MBNA
 A M E R I C ASM
 HALLMARK CENTER SITE HARDENING

OVERALL PLAN

C1.0

C1.0

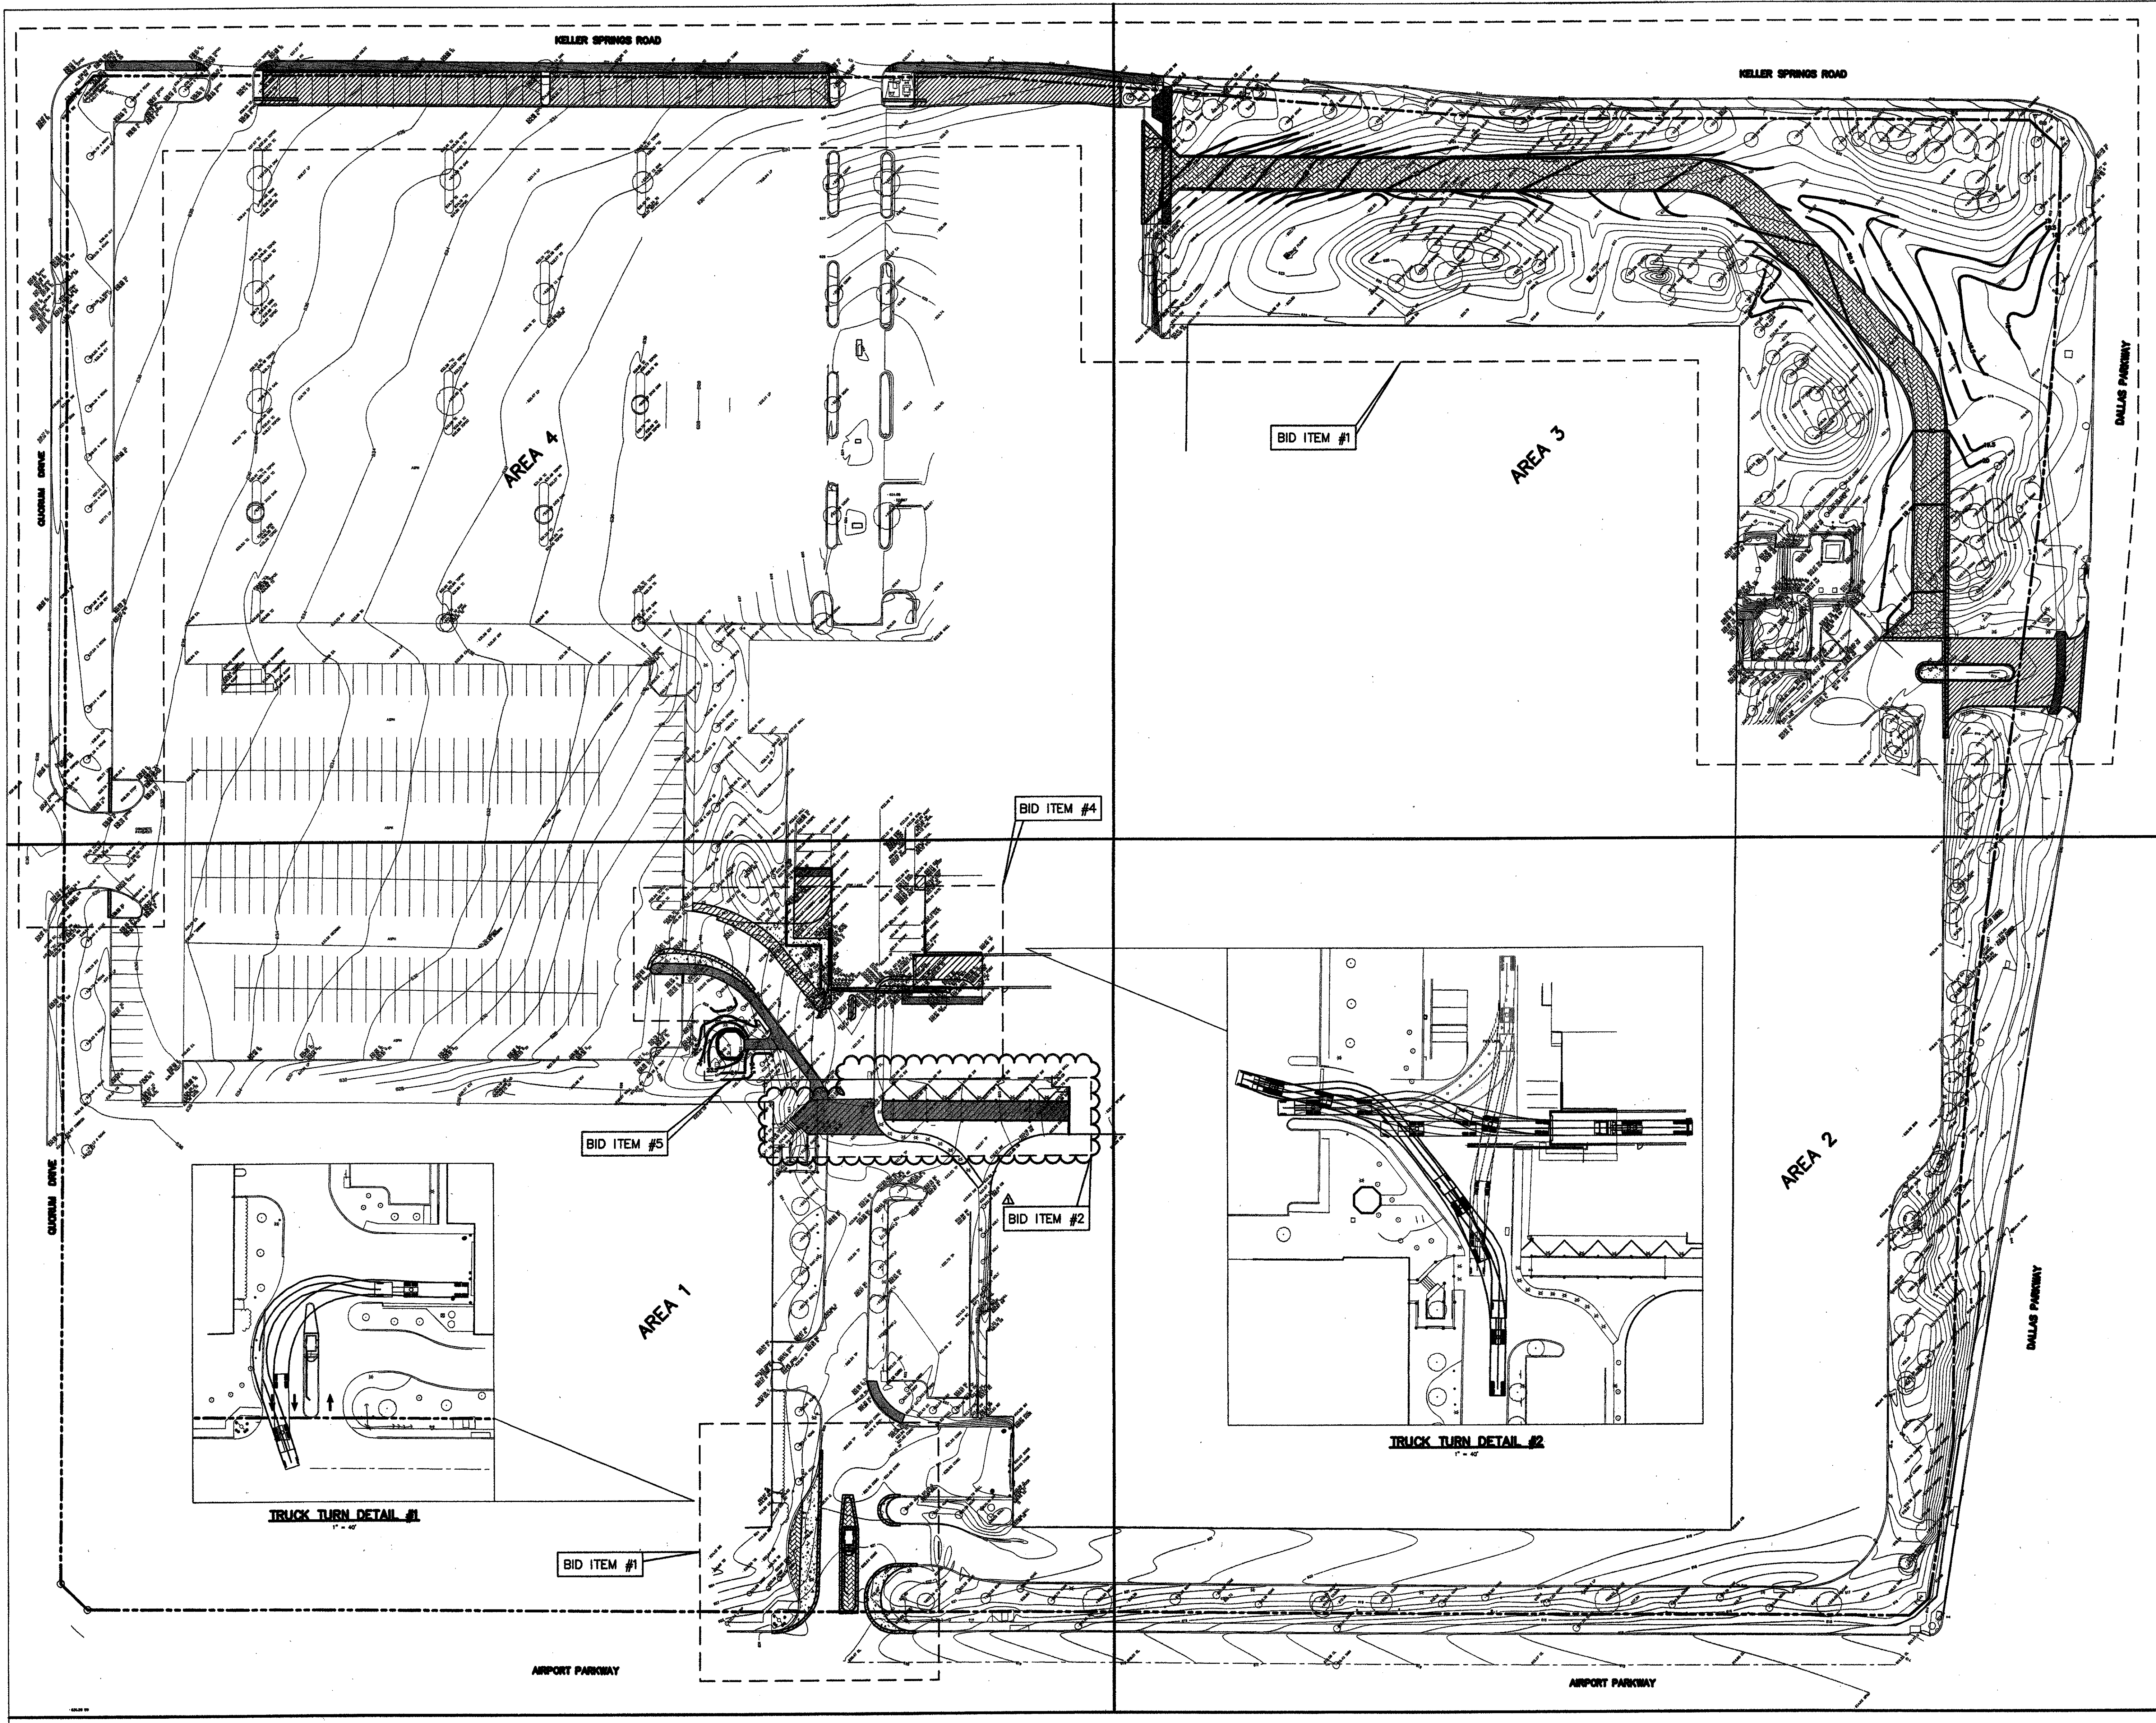
- 1) Obtain ROW Excavation Permit from: Town of Addison Public Works Dept. 16801 Westgrove Rd. Addison, TX 75001
- 2) Note changes to sidewalk + curb Specs. Also SEE ATTACHED
- 3) Curb expansion "bars" are to be placed at all locations where new curb abuts existing.
